Proposal: Amendments to the previous application - Outline application for the construction of the Fitzalan Link Road between the A259 Worthing Road and the East street/Fitzalan Road roundabout - This application affects a Public Right of Way.

Site: Land between the A259 Worthing Road and East Street/Fitzalan Road Roundabout, Littlehampton, West Sussex BN17 6HN.
LU/63/11/

Your Ref
LU/63/11/
Our Ref
S/AR/2011/63
Date: 04/04/2011

Proposal: Construction of the Fitzalan Link Road between the A259 Worthing Road and the East street/Fitzalan Road Roundabout, Littlehampton, West Sussex, BN17 6HN.

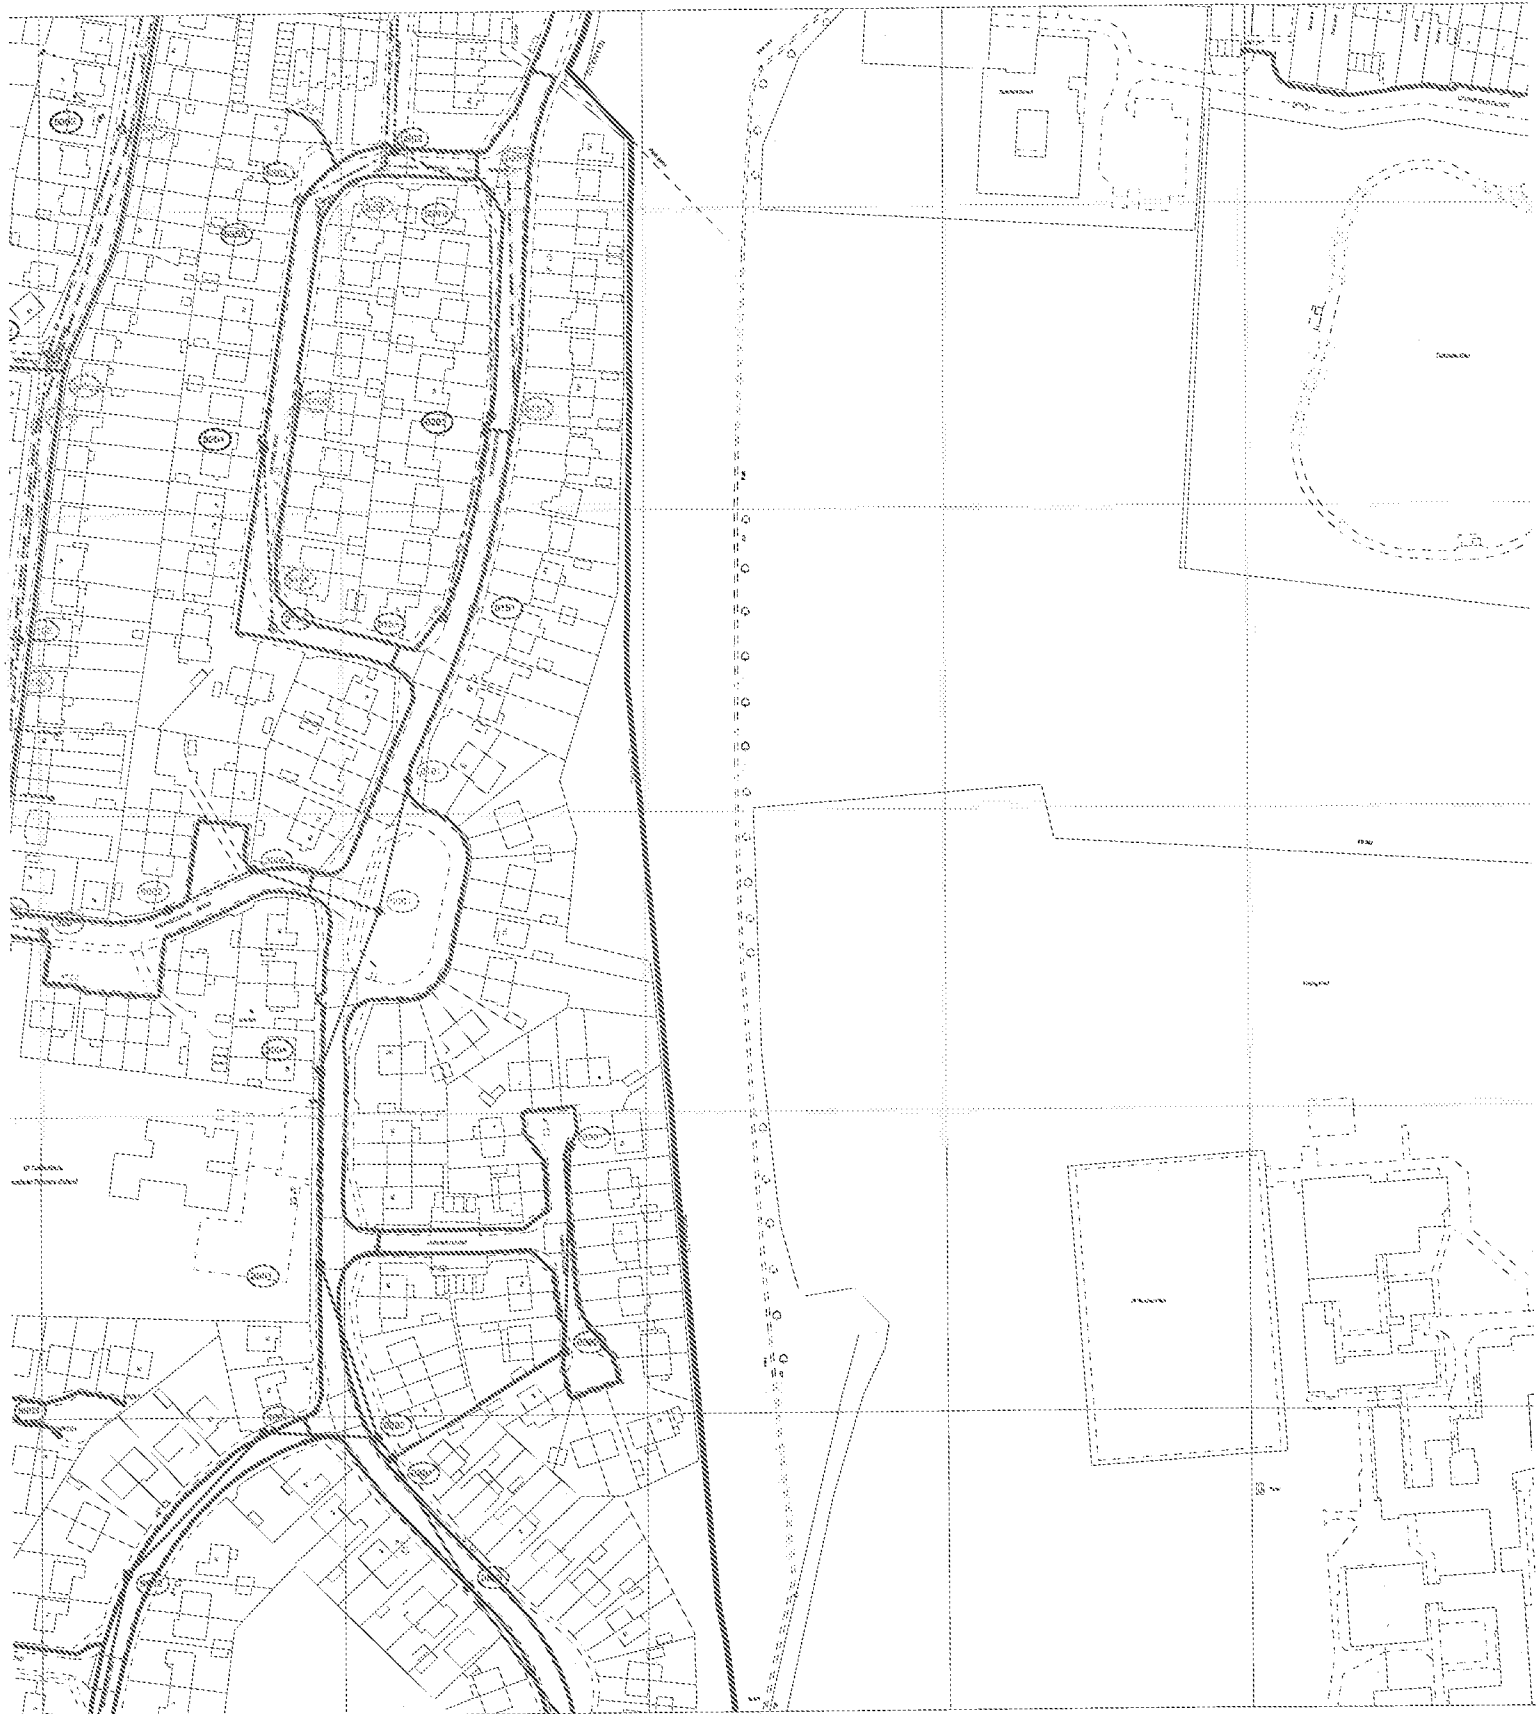
Please find attached a plan of the water main records showing the approximate position of a trunk main crossing the site. The exact position of the public water main must be determined on site by the applicant before the layout of the proposed development is finalised.

Please note that all existing infrastructure, including protective coatings and cathodic protection, should be protected during the course of construction works. No excavation, mounding or tree planting should be carried out within 3 metres of the public water main without consent from Southern Water.

In order to protect water supply apparatus, Southern Water requests that if consent is granted, a condition is attached to the planning permission. For example "The developer must agree with Southern Water, prior to commencement of the development, the measures to be undertaken to protect the public water supply main."
